Ocean Gateway Addition

Wed, Apr 25, 2018 at 10:48 AM

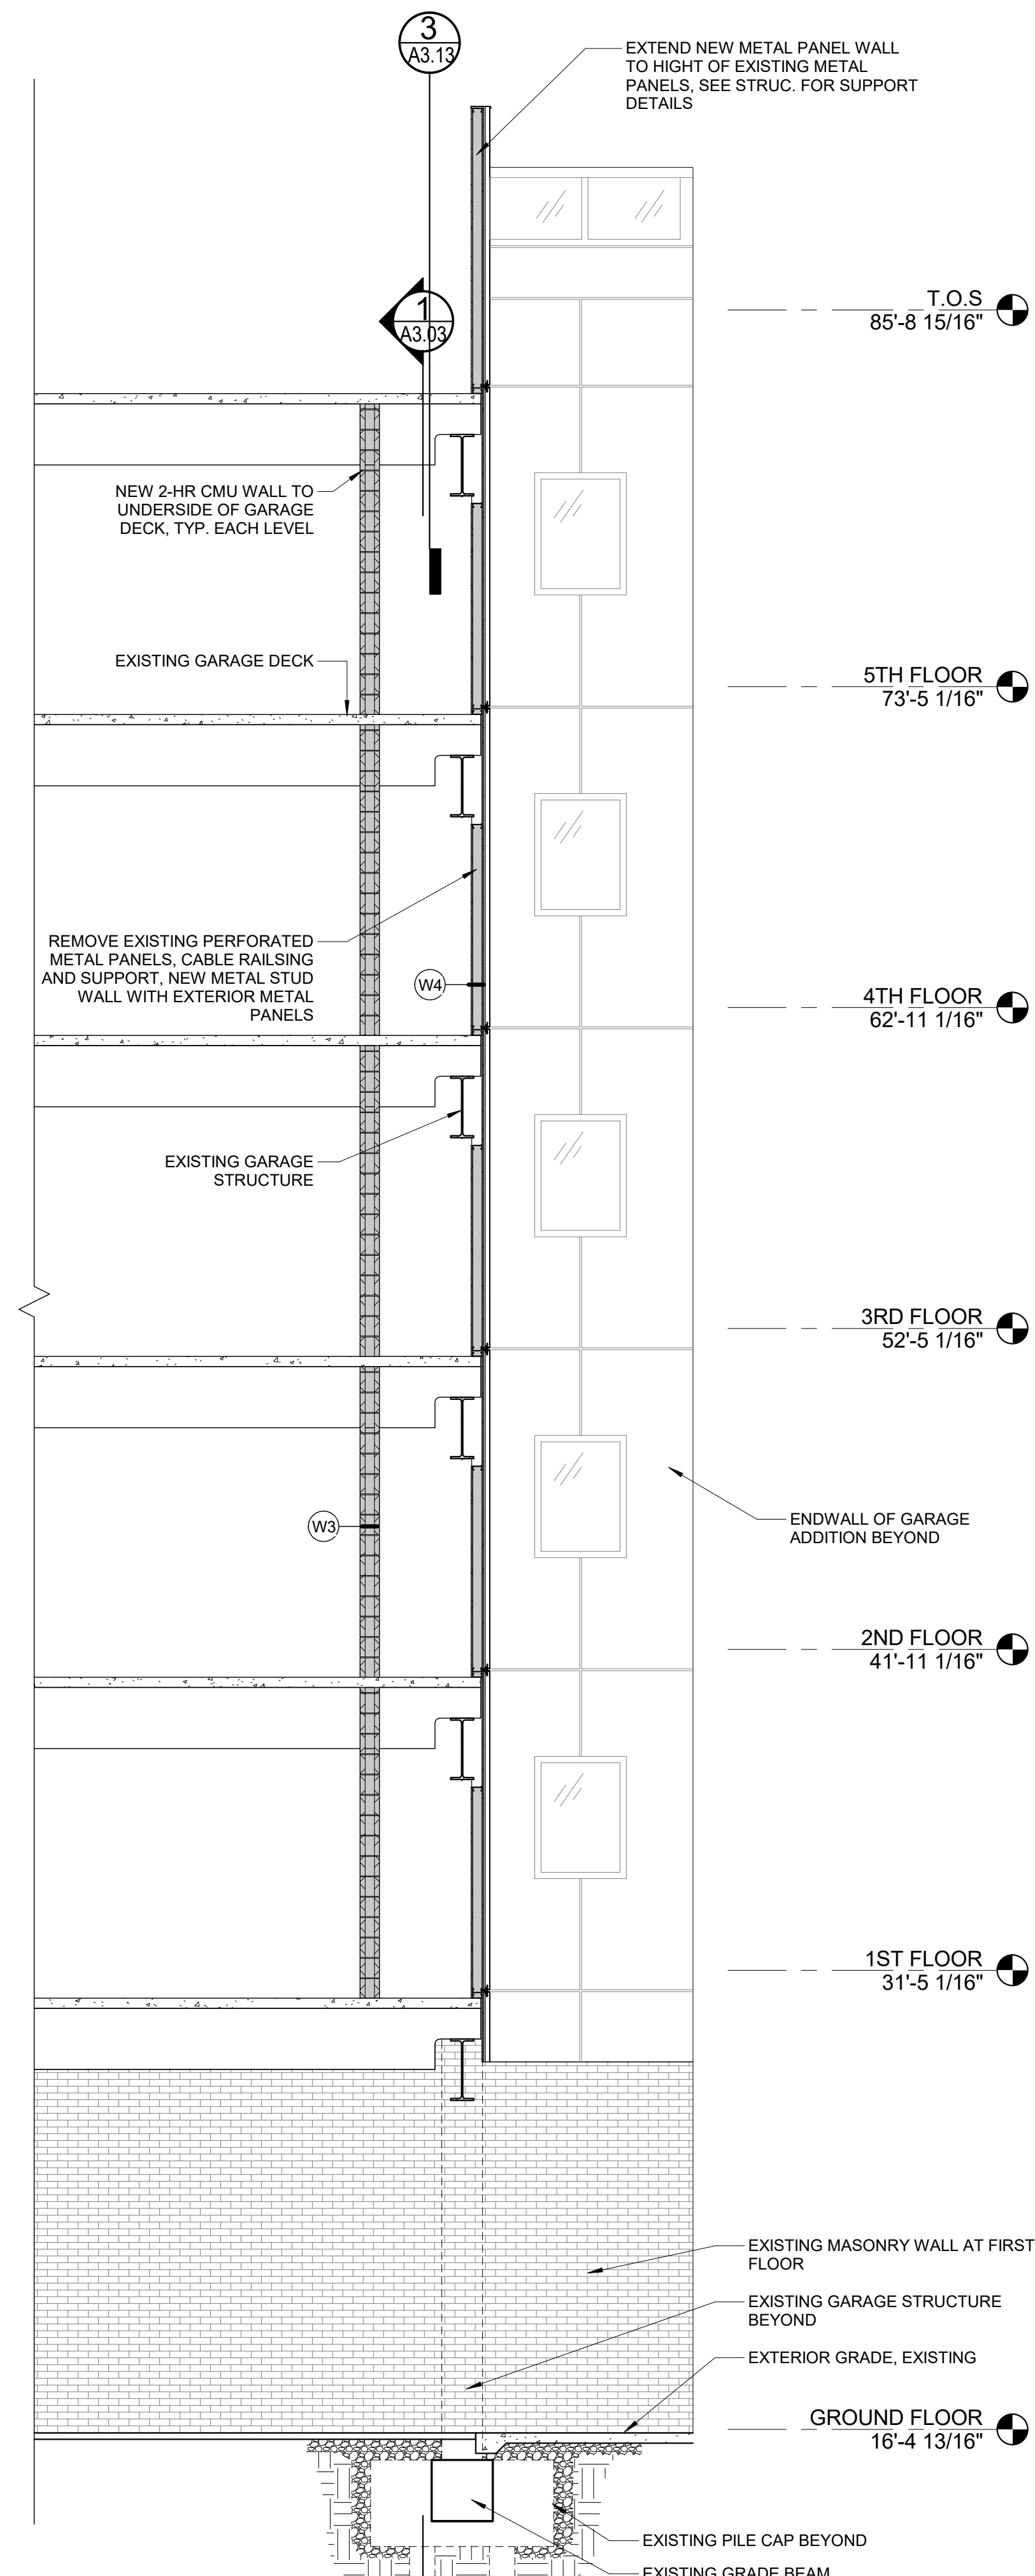
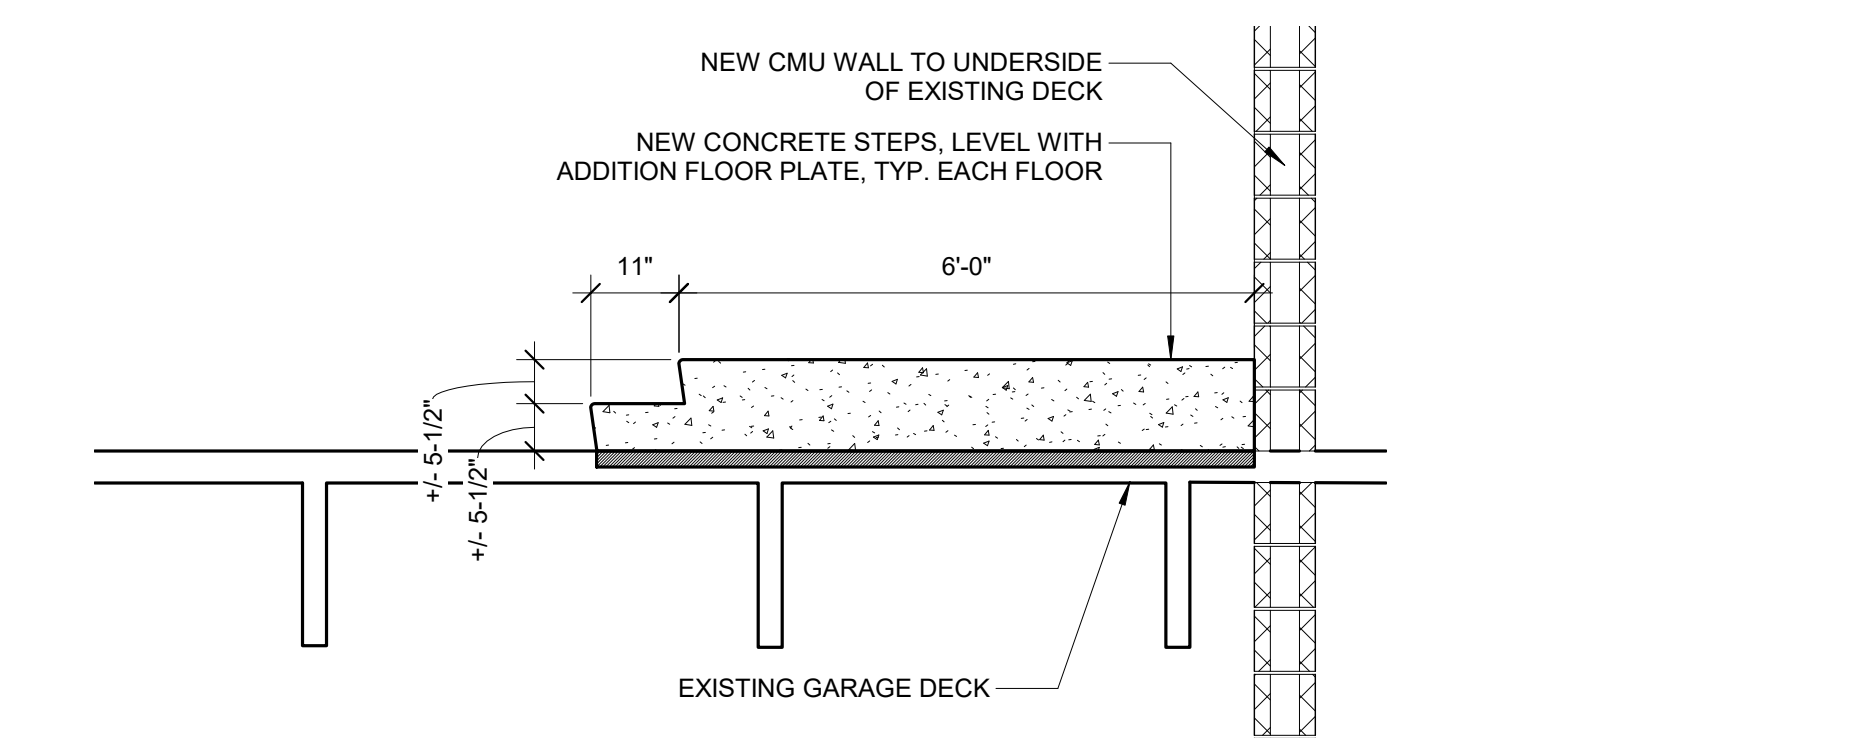
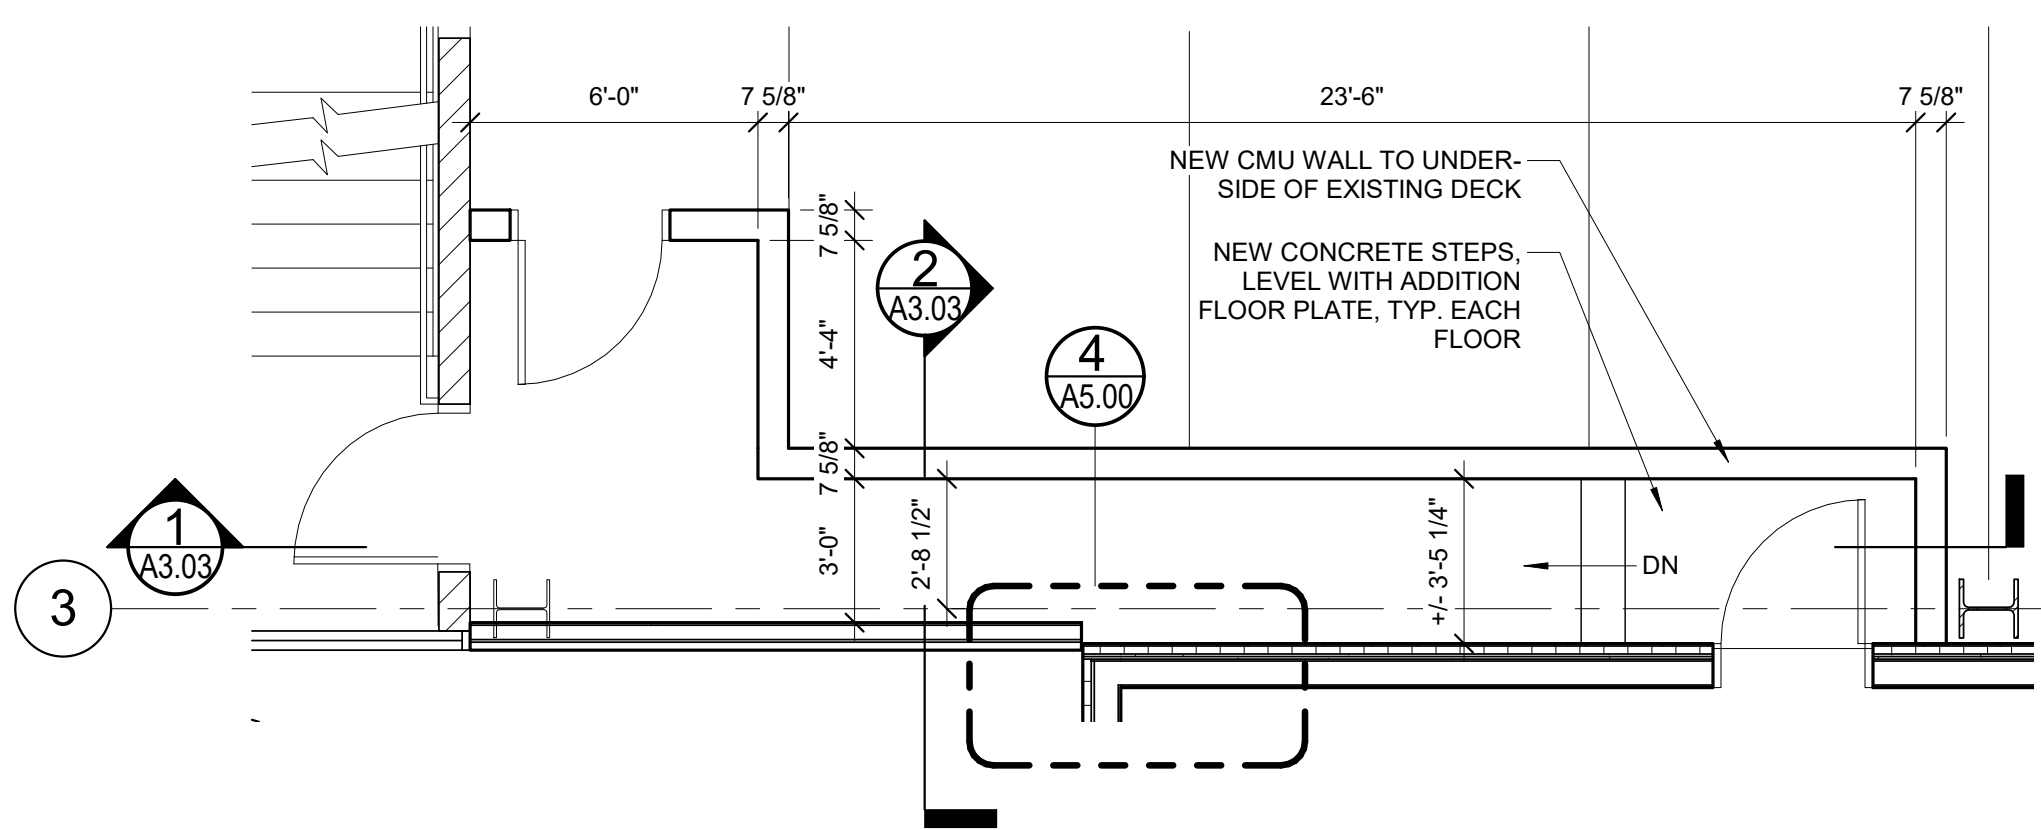
I just had the opportunity to look at the proposed as built plans and notice that the access to this corridor is via steps and a landing. This does not comply with Sec. 1007.1 Accessible means of egress for this business use addition. The original plans utilizing the left hand stair did not show a change in elevation from the office to enclosed egress.

I attached the plans and details that were part of the original submission. These plans, which were approved, did show the elevation change in the enclosed egress corridor.

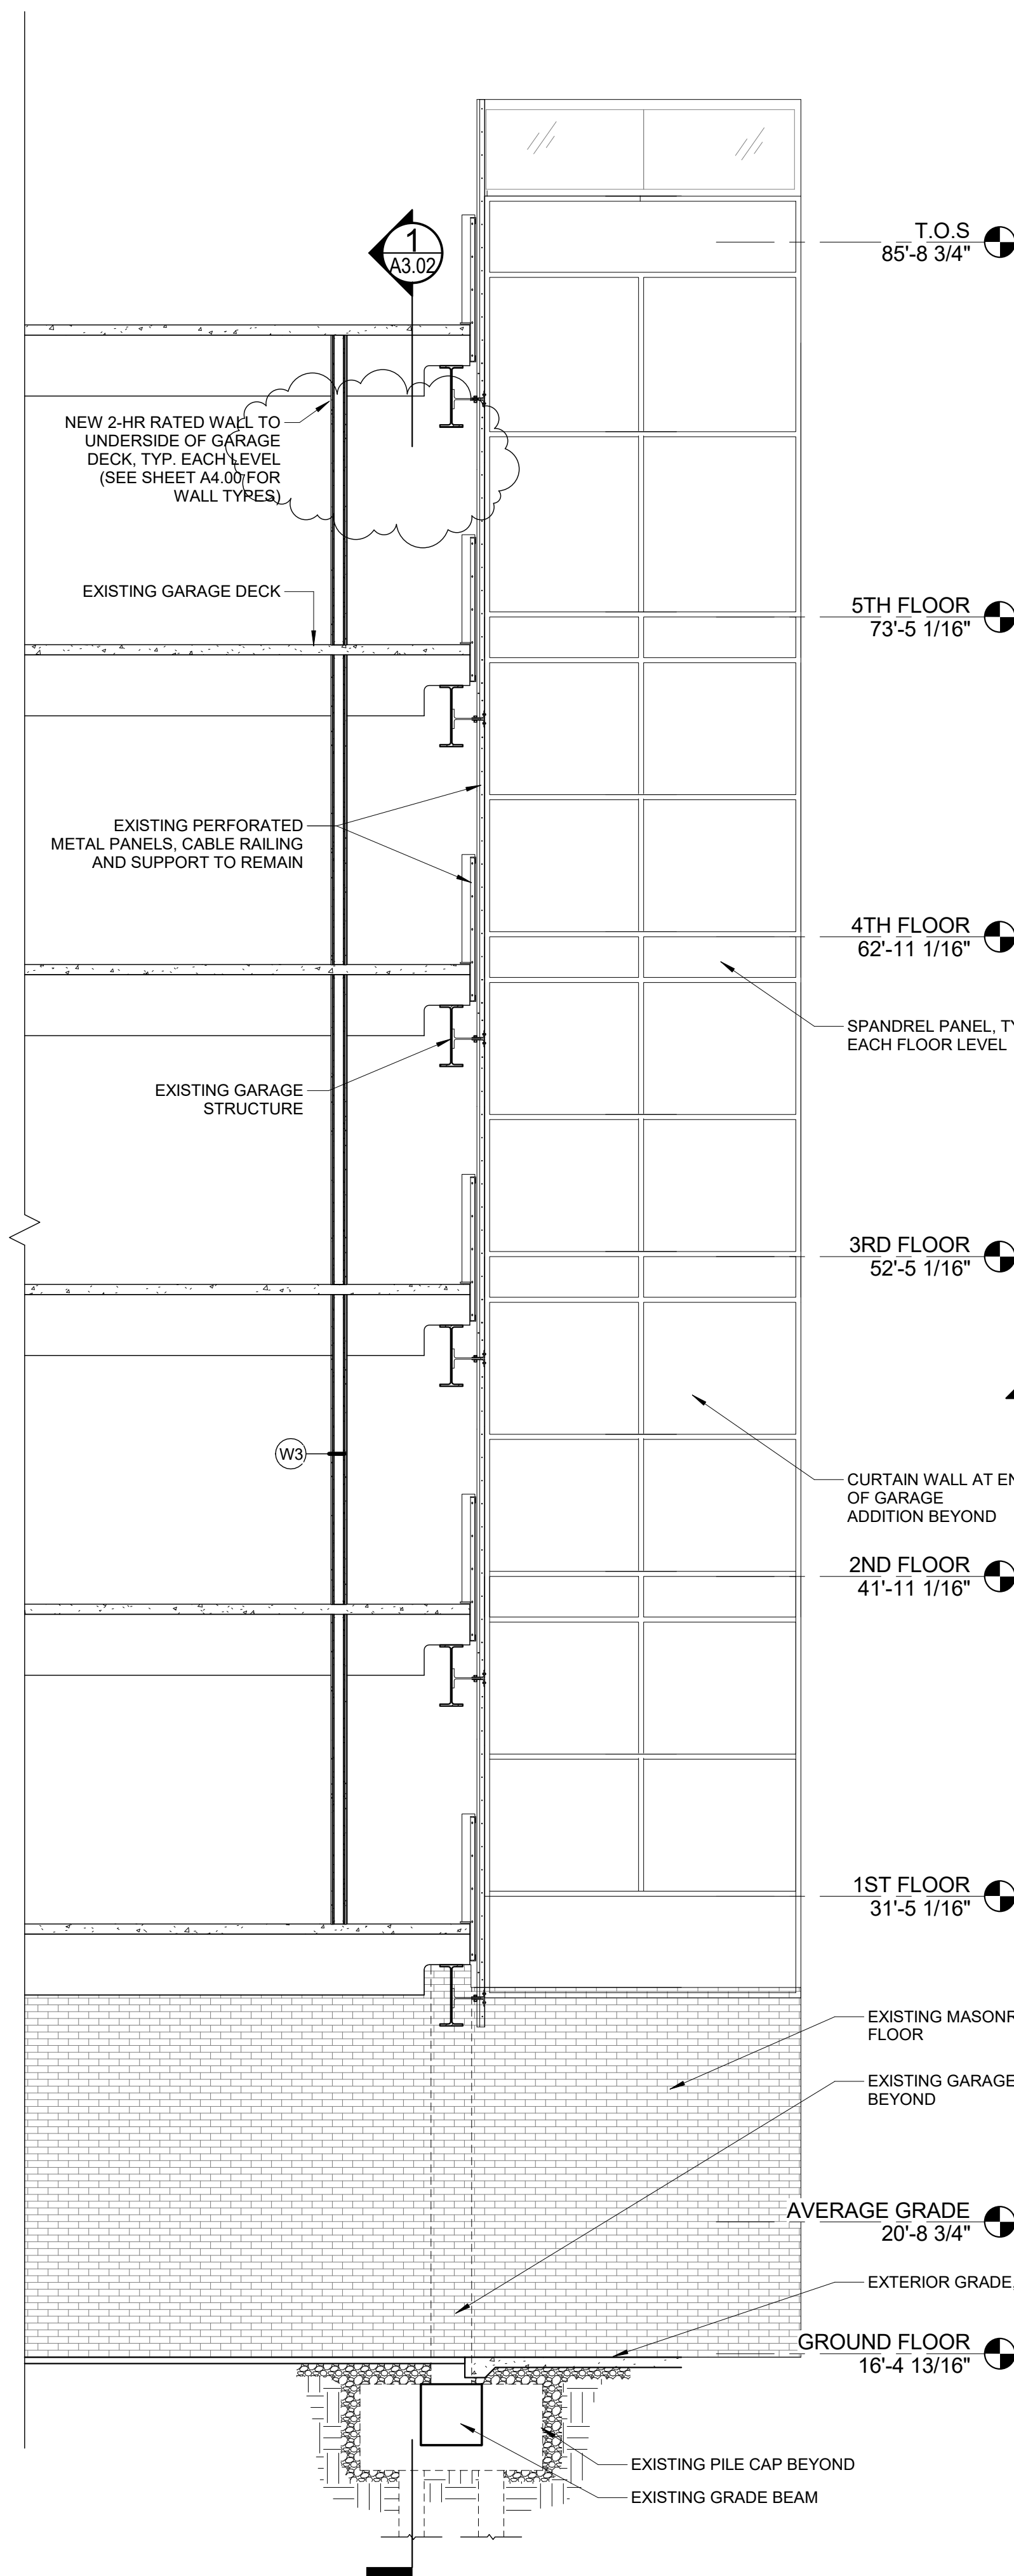
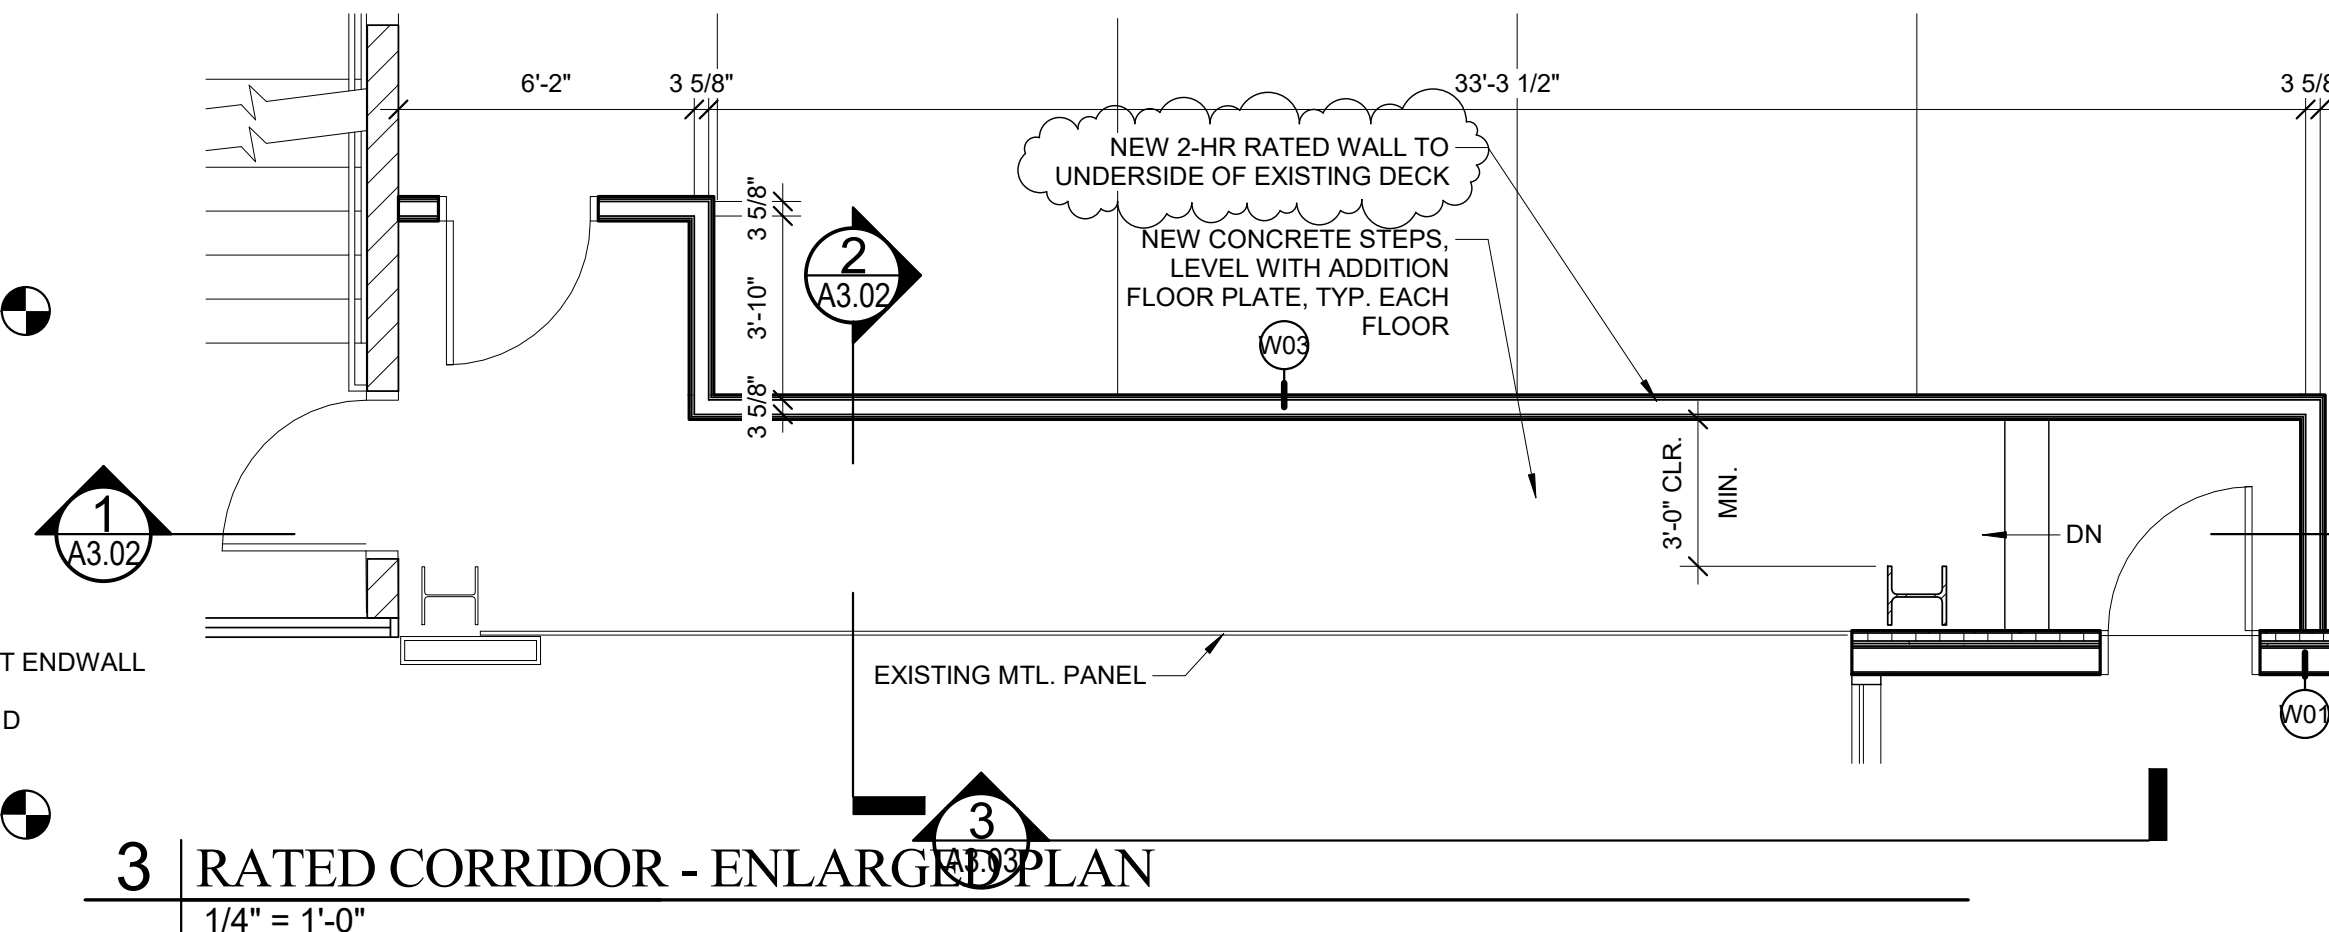
The issue is that the one means of egress from the business use also needs to be the accessible means of egress. Please note that revised plan sheets A3.02 and A3.03 also need to be submitted.
